From: Laura Gibbons <Laura.Gibbons@arun.gov.uk>
Sent: 01 July 2021 15:39
To: Planning.Responses <Planning.Responses@arun.gov.uk>
Cc: Simon Davis <Simon.Davis@arun.gov.uk>
Subject: FW: Planning Consultation on: P/84/21/DOC

Condition 6- surface water drainage design

Application No: P/84/21/DOC

Site Address: 253-255 Pagham Road Pagham PO21 3QB

Drawing Status	FOR APPROVAL						
Client	Future Group Development Ltd						
Project	Land at The Inglenook Pagham Road, Bognor Regis PO21 3QB						
Drawing Title	Proposed Drainage Arrangement Sheet 2 of 2						
Scale	1:200	Date	May 2021	Drawn By	DJL	Checked By	MJA
Drawing No.	D1966-103.2	Rev.	-

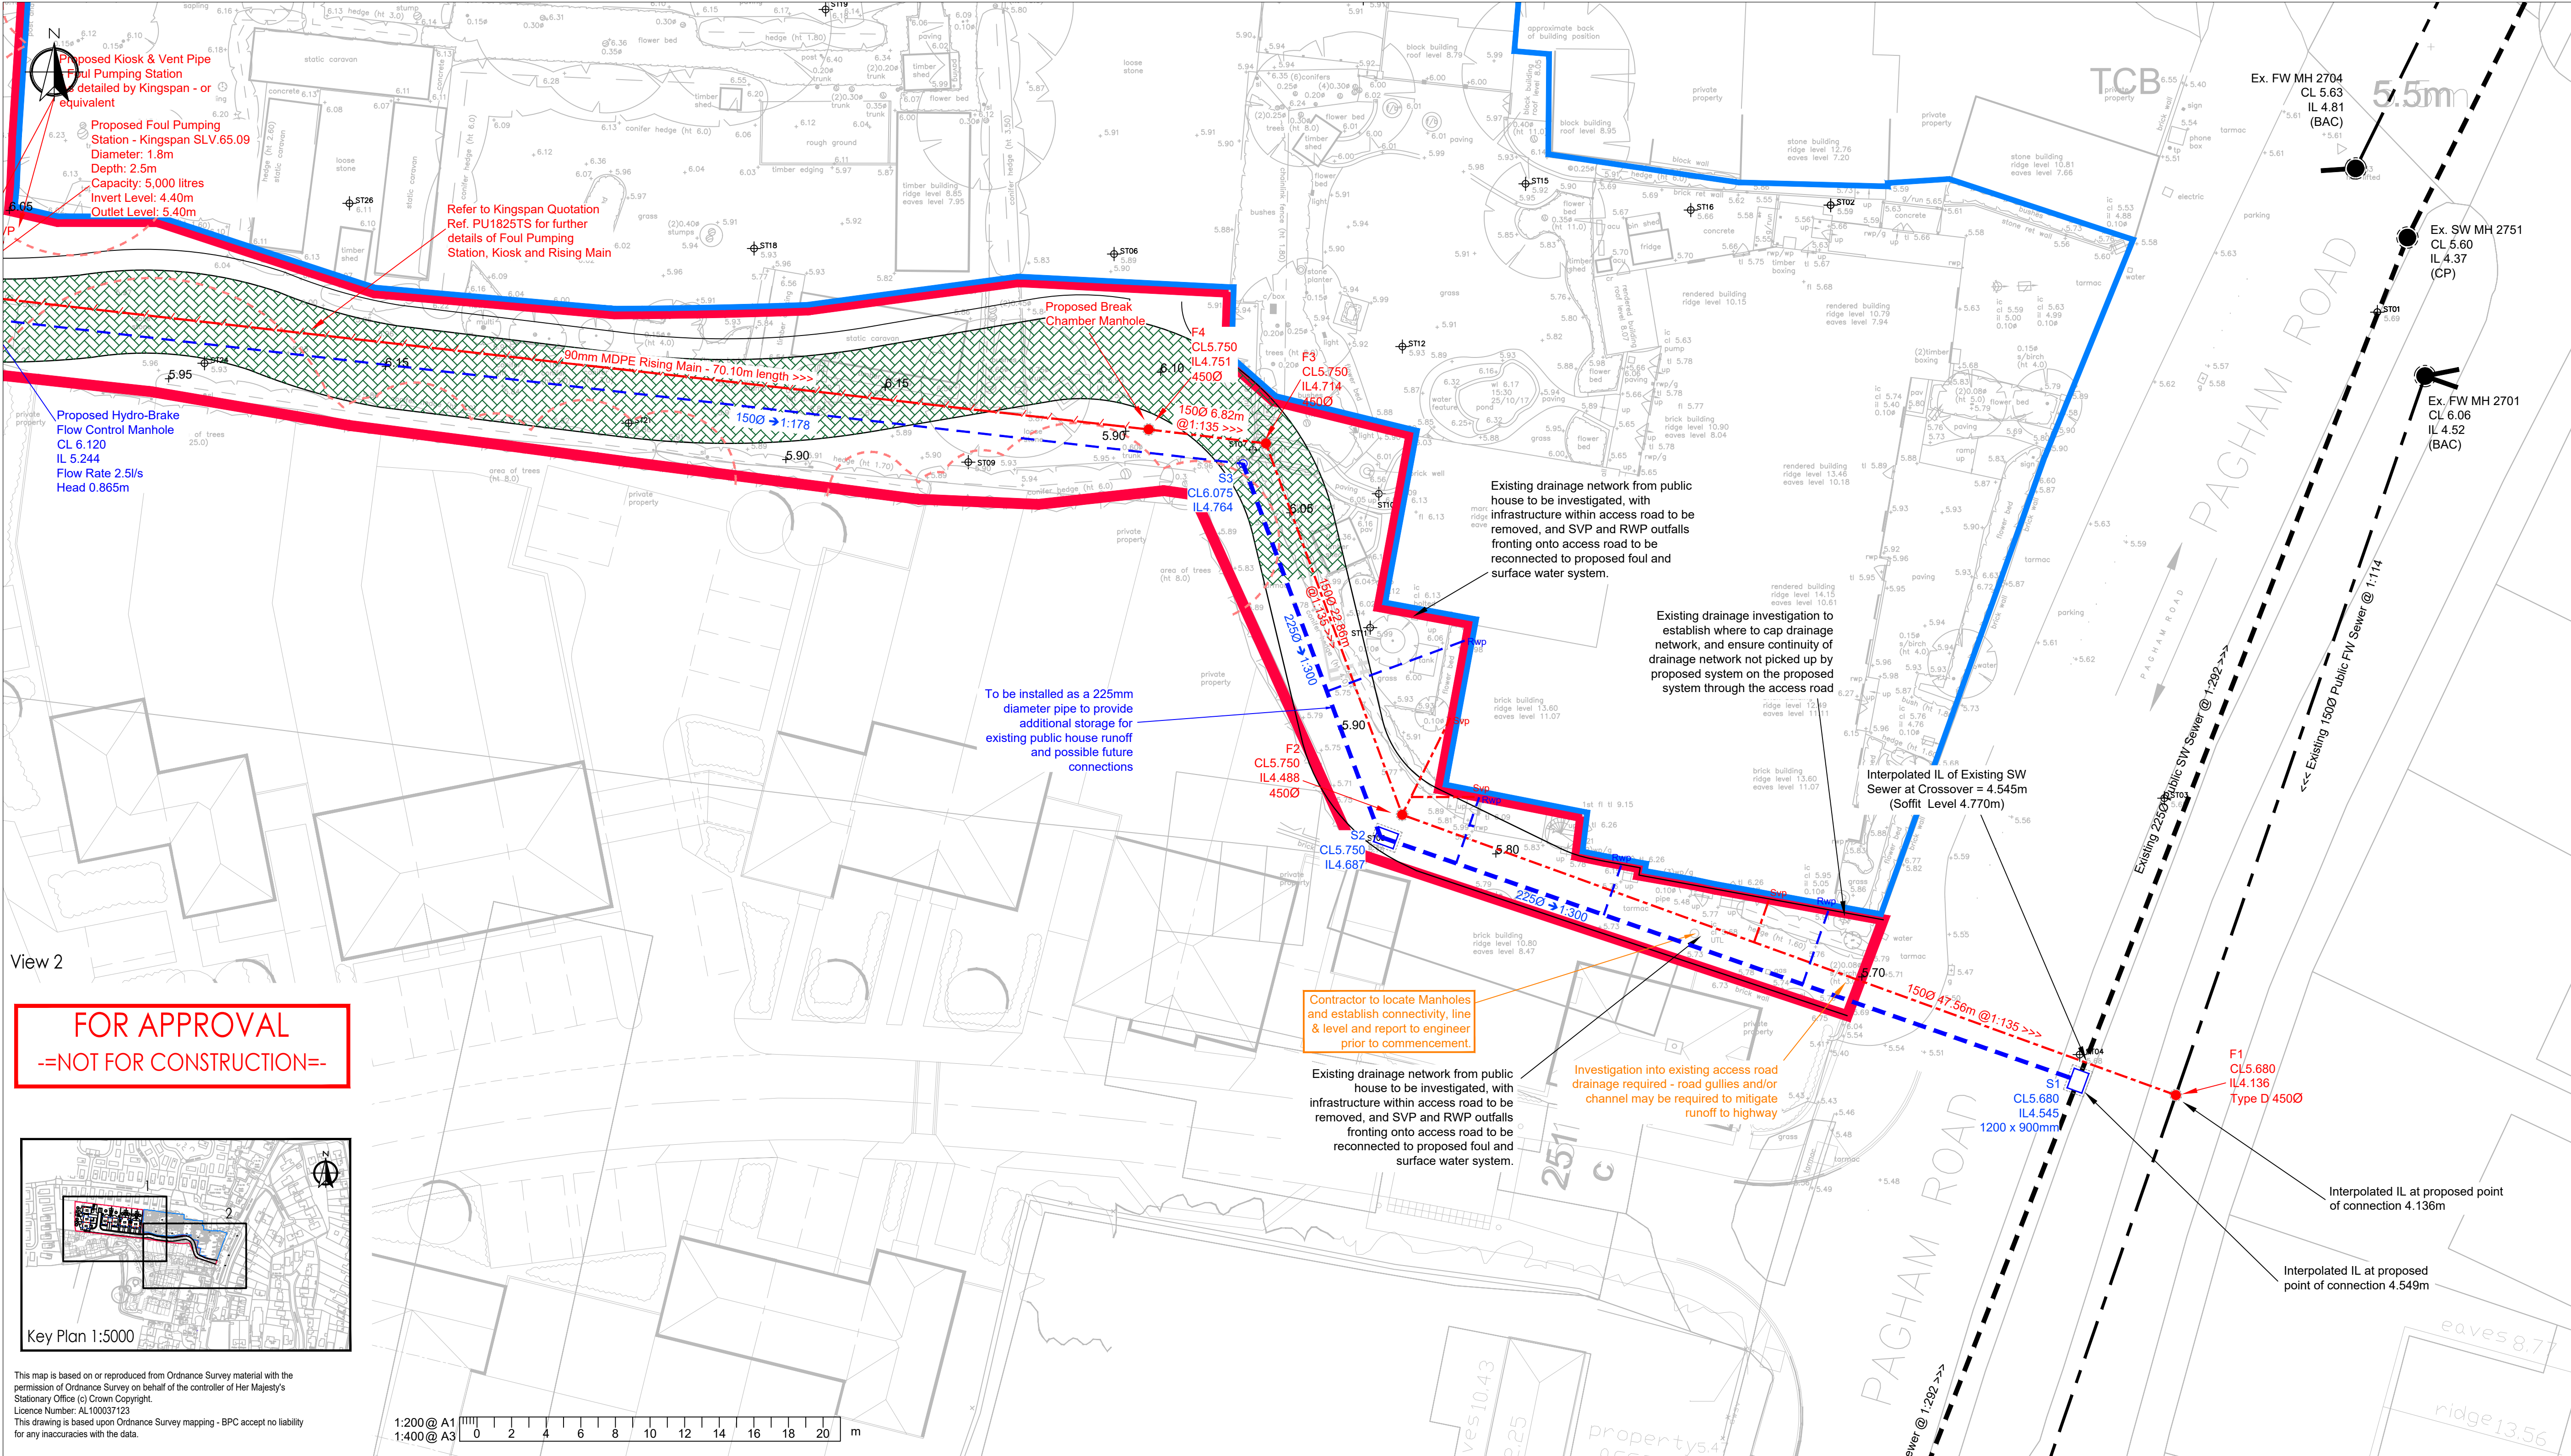
1. Please can the applicant submit a catchment area plan
2. Please can the applicant submit greenfield runoff calculations
3. Please can the applicant submit winter groundwater and infiltration testing here. We have had previous discussions directly with the applicant's consultant, but the testing/ monitoring information should be submitted with this application.
4. Please detail formation level of permeable paving on plans.
5. Please state hydrobrake reference on both layout and construction detail.
6. Please show hydrobrake bypass door, operating rope and fixing and construction detail.
7. Please confirm if lowest invert of sub-base and correct slope are modelled correctly in calculations.

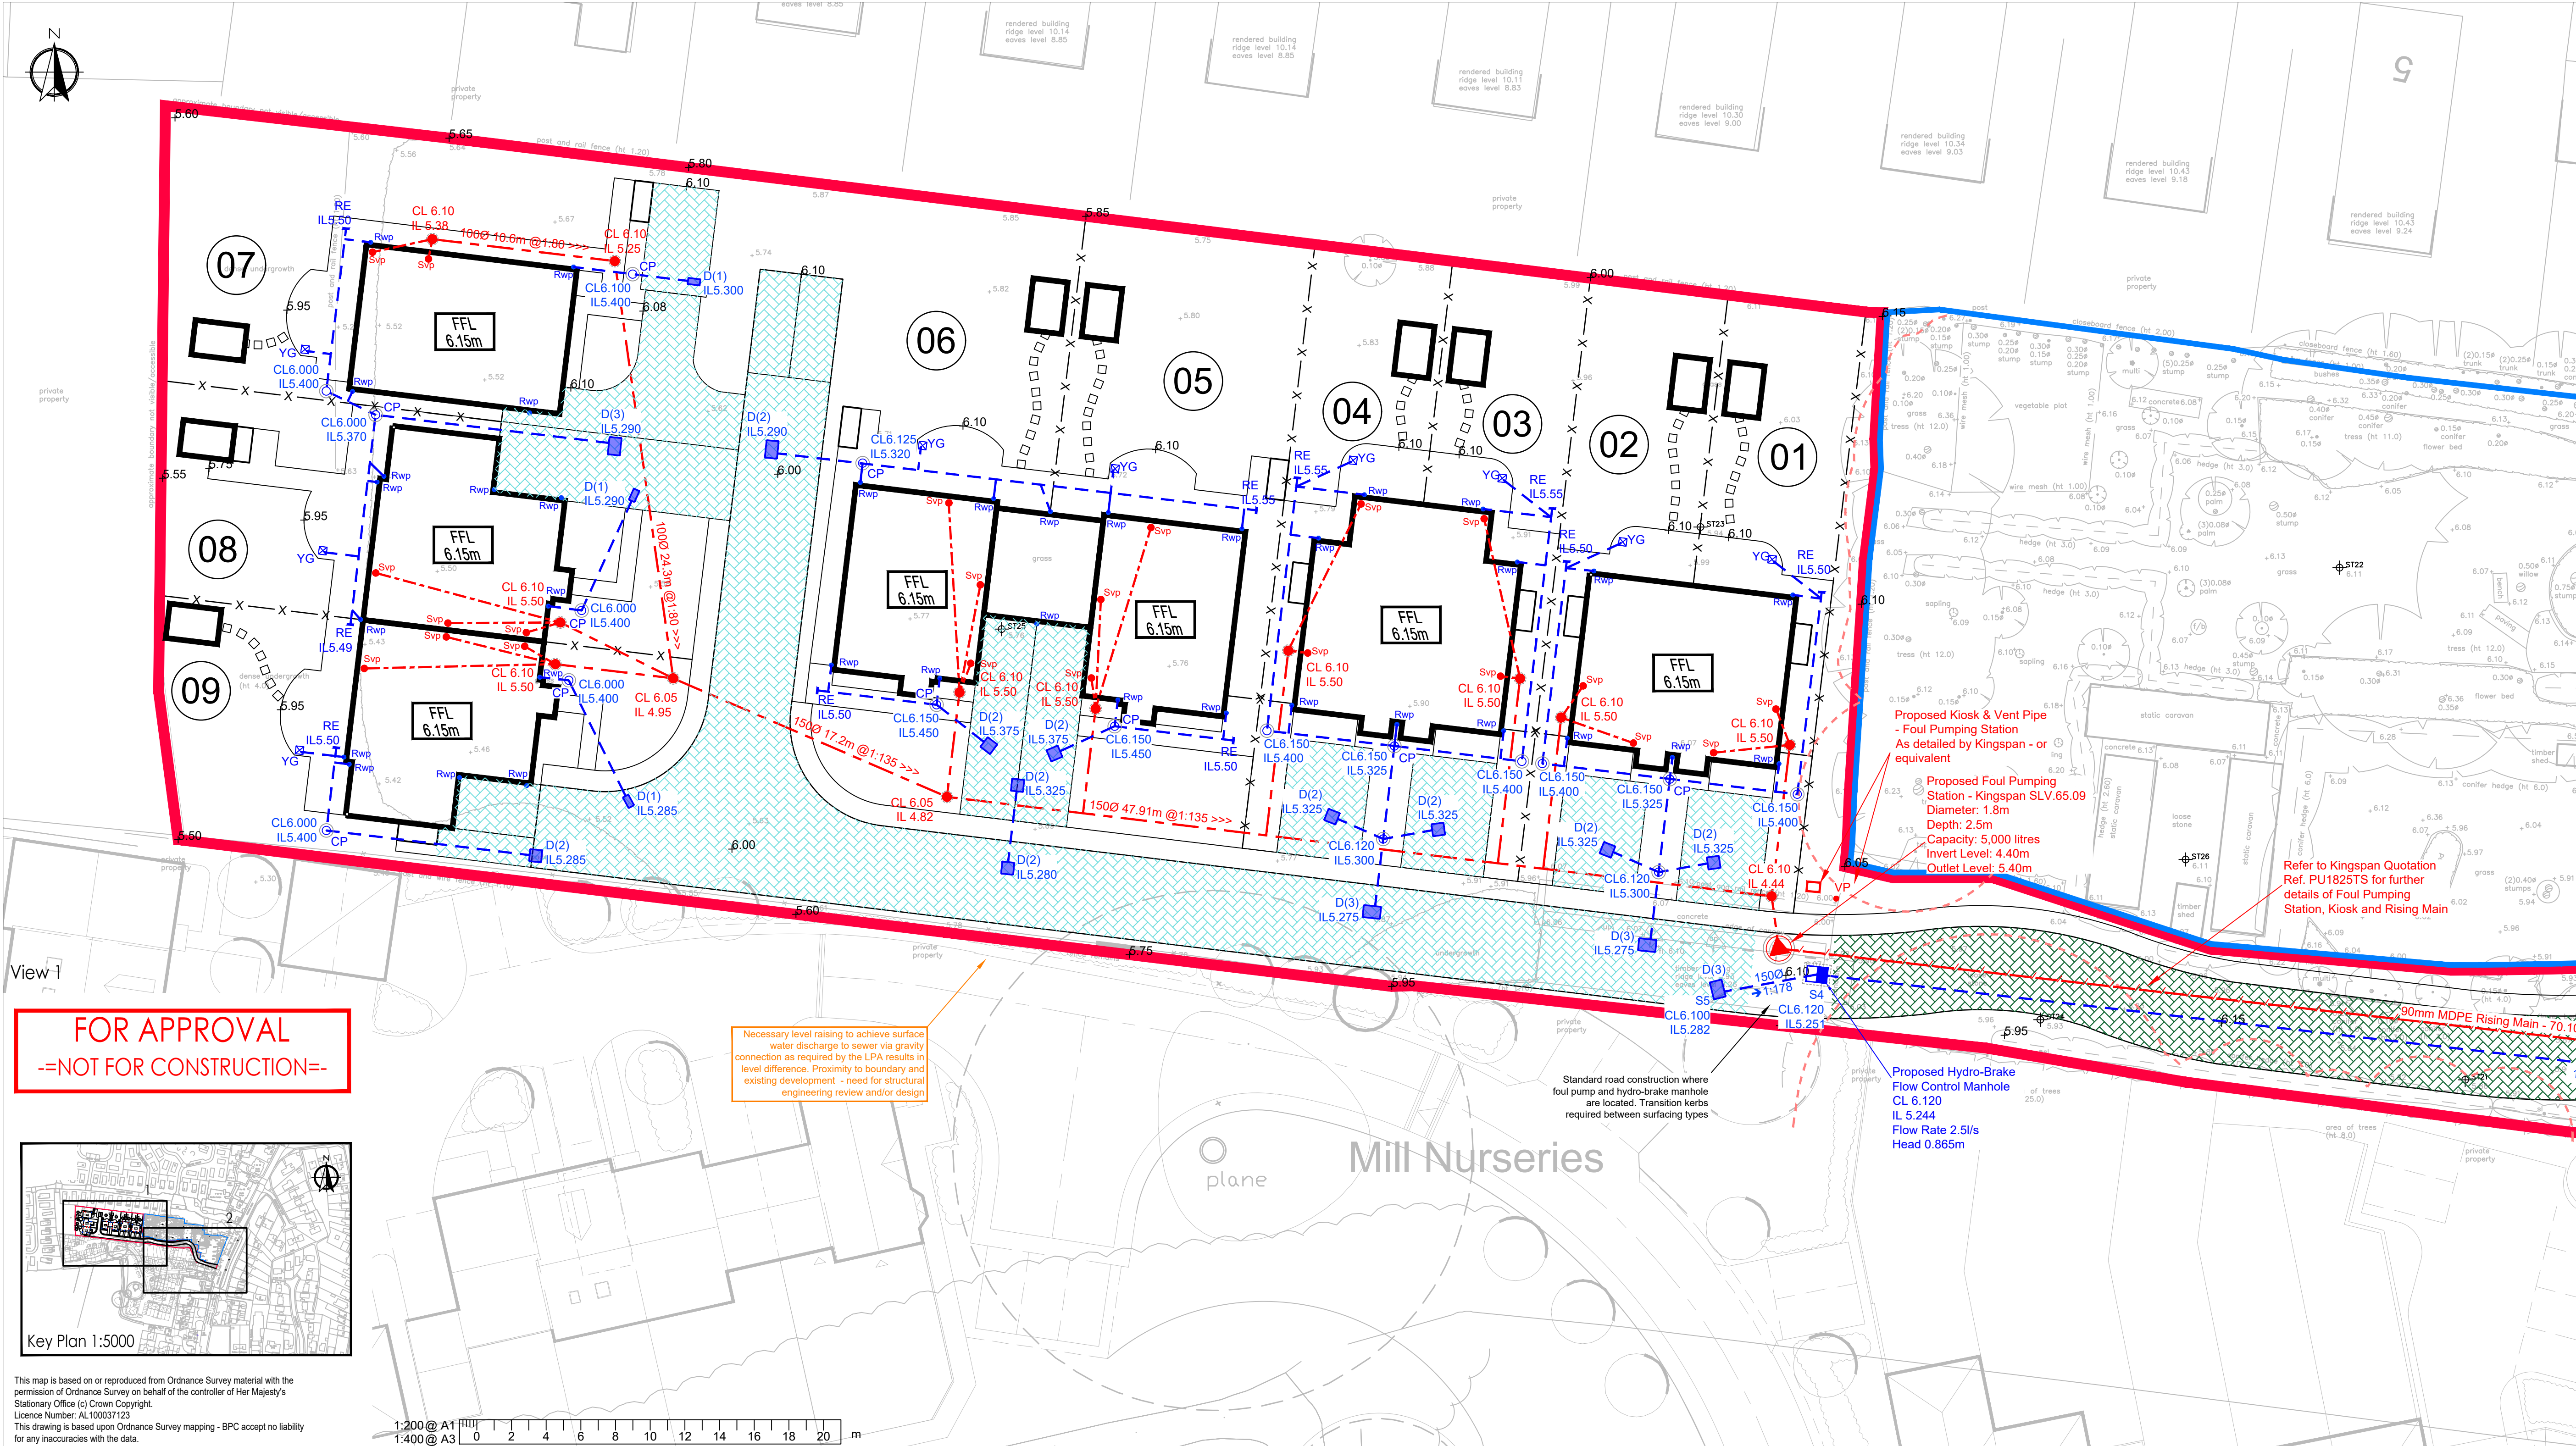
8. Please supply evidence of southern waters acceptance of proposals. E.g. S106 approval and capacity check.
